RE: STATE SIGNIFICANT DEVELOPMENT APPLICATION (SSD 9522) FOR PROPOSED WAREHOUSE, LOGISTICS AND INDUSTRIAL FACILITIES HUB

PROPERTY AT: 657-769 MAMRE ROAD, KEMPS CREEK (LOT 34 DP 1118173, LOT X DP 421633, LOT 1 DP 1018318, LOT Y DP 421633 & LOT 22 DP 258414)

RE: 657-703 Mamre Road, Kemps Creek (SSD-9522) – Response to TfNSW RFI

Table 1: TfNSW Comments (27/09/2020) and Ason Group Response

Annexure A - Mamre Road Works PlanA handwritten signature in black ink, located in the bottom right corner of the page. The signature is stylized and appears to be a cursive or semi-cursive script.

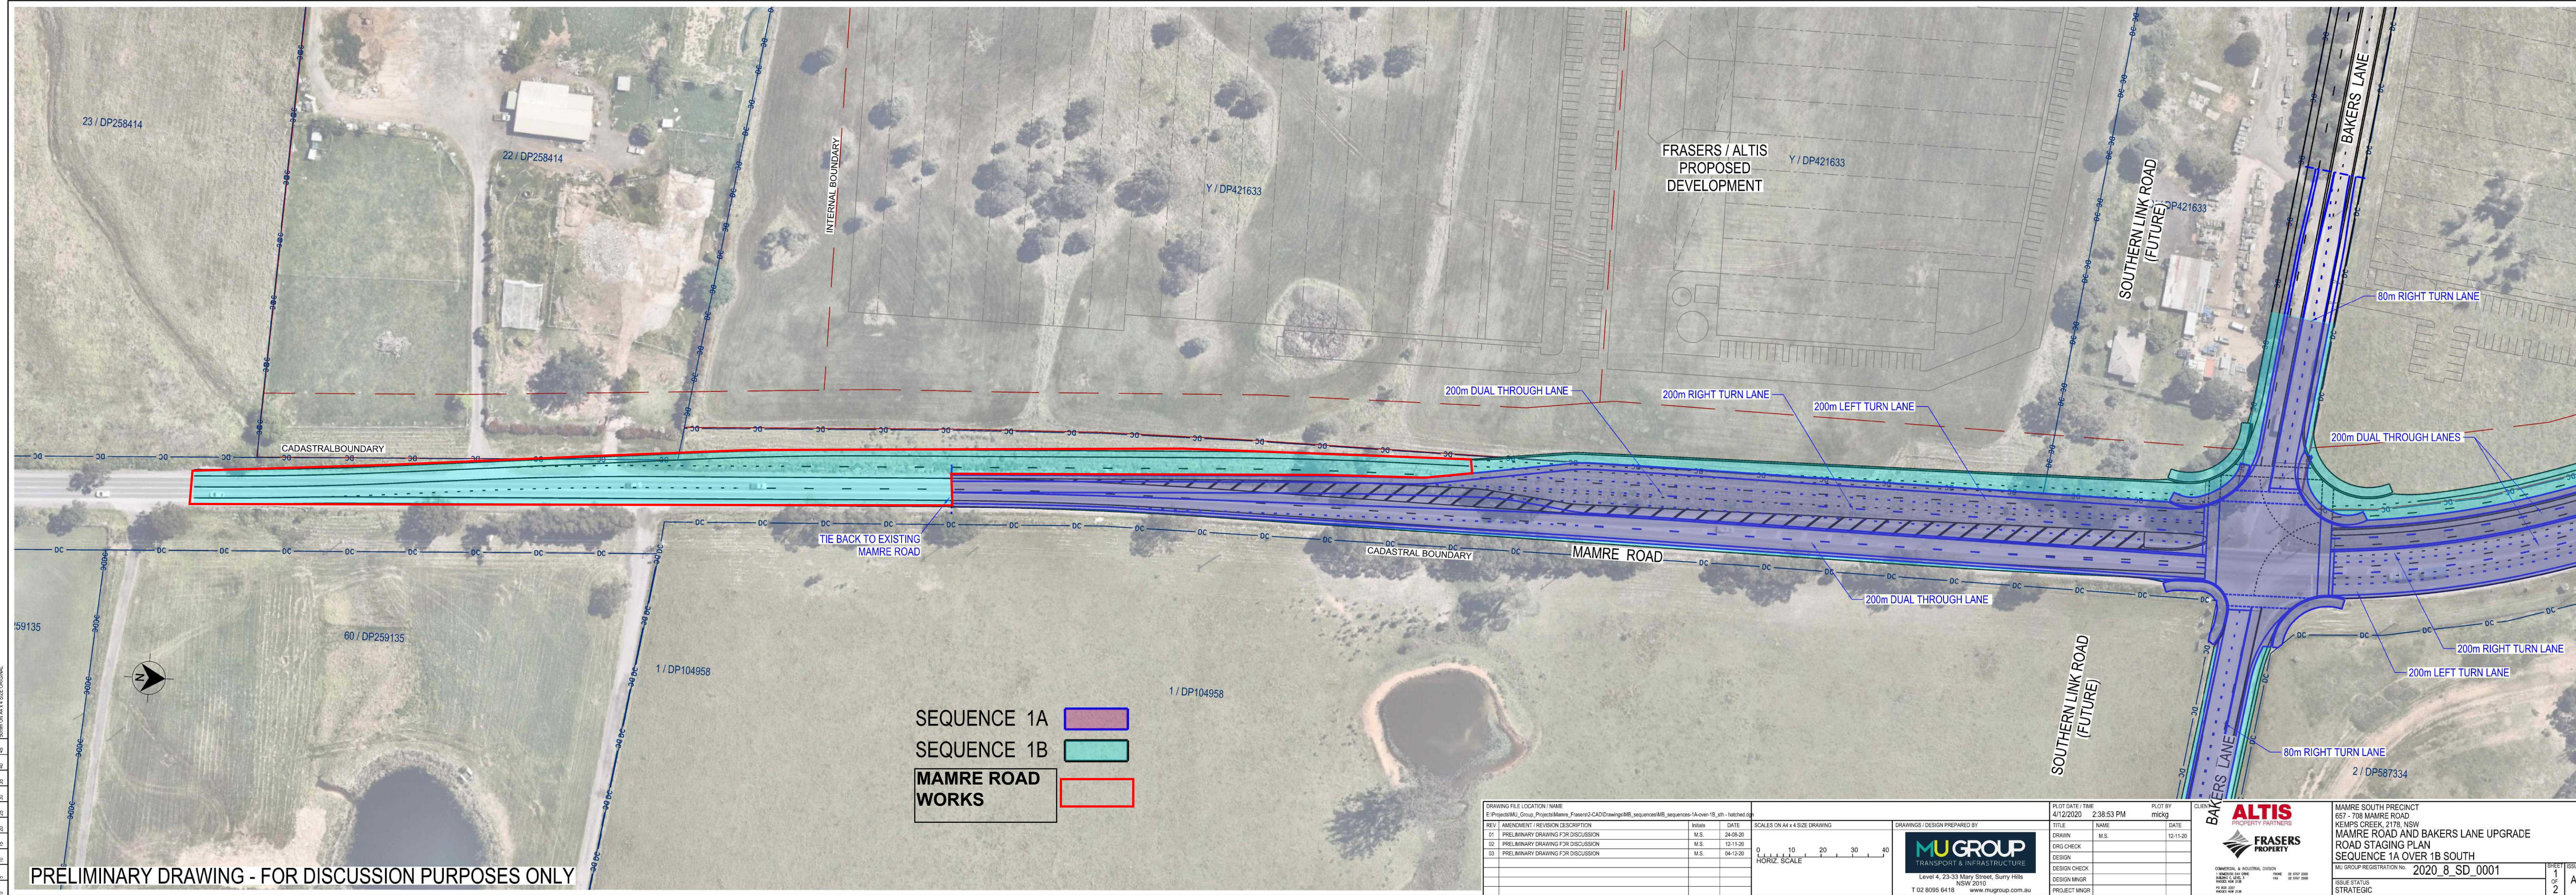
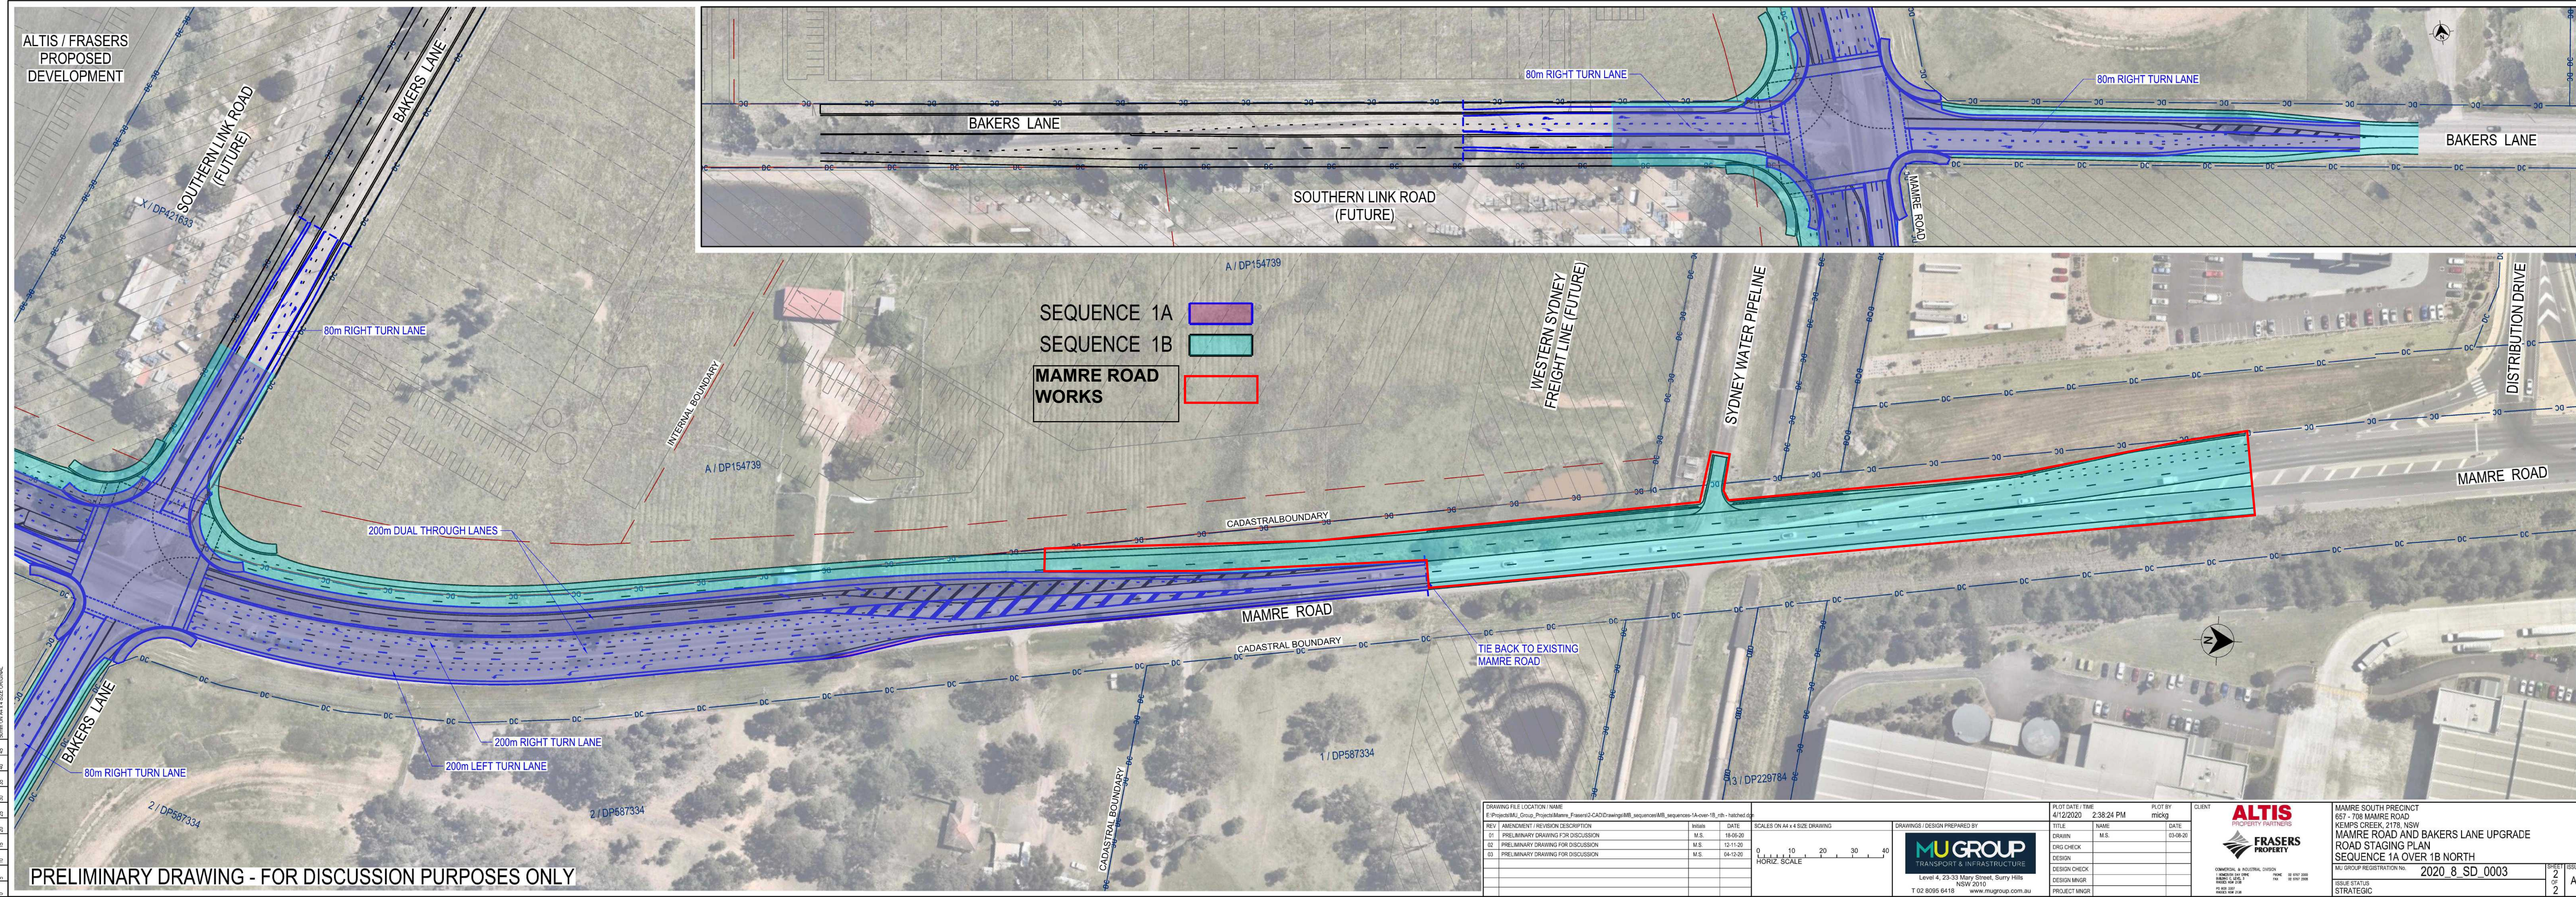
Item No.	TfNSW Comment	Ason Group Response
1)	TNSW previously noted the documentation provided is not consistent. The response to submissions addendum, states that the design provided in this SSDA cannot be achieved within the existing SP2 corridor for Mamre Road. Any changes to the design may alter the LoS to the intersection and therefore the modelling and traffic report provided will not be accurate. This could lead to unknown delays to the network and adverse safety outcomes. Therefore, noting the above, TfNSW cannot provide support under Section 87 of the <i>Roads Act, 1993</i> . To enable TfNSW to consider "Agreement in Principle" to the signals at this location under Section 87 of the, <i>Roads Act, 1993</i> .	
i	Concept (or Strategic) Civil Plan	A copy of MU Group Strategic-Concept plan for Mamre Road / Bakers Lane intersection in relation to SSD-9522 is provided in Attachment 1 . It is noted that the Strategic-Concept Design prepared by MU Group supersedes the Sequence 1B design included in the latest Traffic Impact Assessment (TIA) dated 03 August 2020. The Strategic-Concept Design prepared by MU Group also covers the lane requirements for both Sequences 1A and 1B as described in the TIA.

iv	Traffic Report – information is to be consistent with the actual proposed design	<p>The traffic analysis and SIDRA modelling undertaken for the Sequence 1B at Mamre Road / Bakers Lane is generally consistent with the Strategic Plan design (included in Attachment 1) which can satisfactorily address this comment.</p>
v	Warrant Assessment	<p>The intersection of Mamre Road and Bakers Lane is currently a three-leg, T-intersection operating under traffic signal control. The proposed design results in an additional western leg being at Bakers Lane, hence maintaining its current control.</p> <p>Notwithstanding the above, The TIA dated 03 August 2020 supports warrant under Section 2.3 of the Traffic Signal Design Guidelines for a signalised intersection to be considered.</p> <p>For clarity, TIA appendices show the traffic movements on Major road (Mamre Road being more than 600 vehicle/hr) and the minor road (Bakers Lane western leg of the signal exceeding 200 veh/hr) during the road network AM and PM peak hours. It is noted that the Sequence 1B will not only provide access for the SSD traffic, it may also provide vehicular accessibility for the wider precinct (under full development) as well as the Southern Lots traffic (if Southern Link Road is not implemented).</p>
